JENISHAY FARMS Civil Construction Plans

Including Grading and Erosion Control

El Paso County, Colorado

Prepared By:
Lodestar Engineering, LLC
P.O. Box 88461
Colorado Springs, CO 80908
October 2019

RURAL LOCAL – PAVED  
TYPICAL SECTION  
SCALE N.T.S.

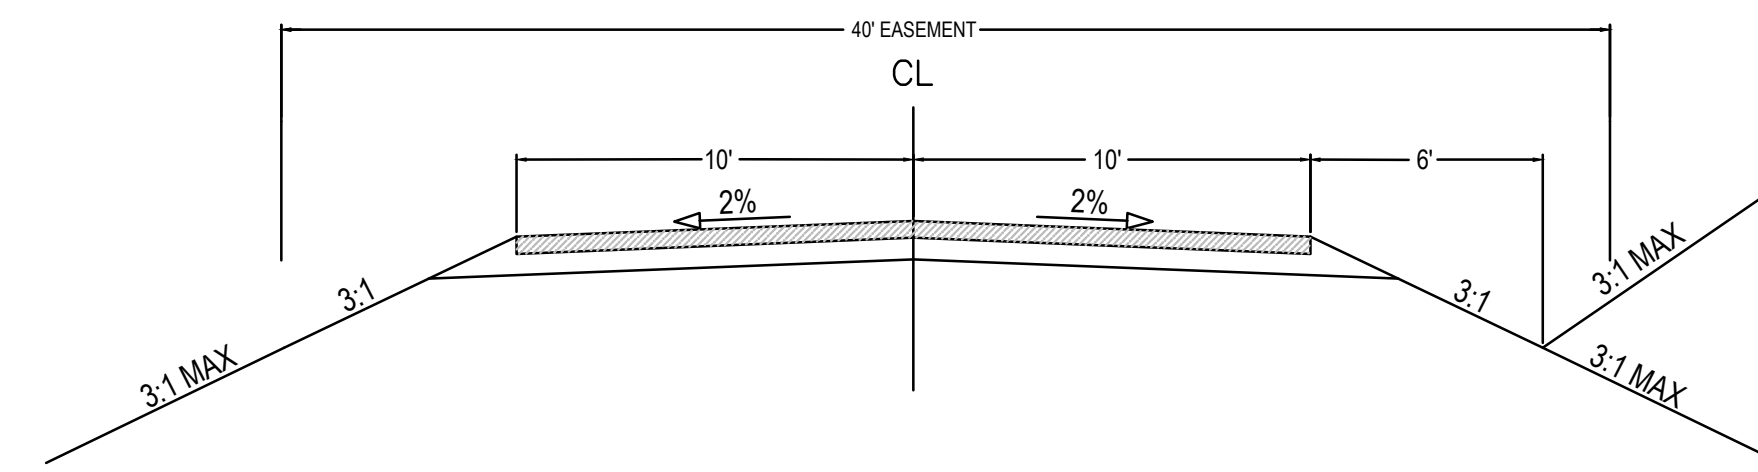
- Preliminary grading sheet:**
1. Change the title of this sheet to preliminary grading
 2. Remove the temporary BMPs
 3. Add road centerline grade tag and on the cul-de-sac bulb. Intent is to show the road vertical alignment generally meets criteria in the preliminary plan stage.
 4. Include the typical road section detail.
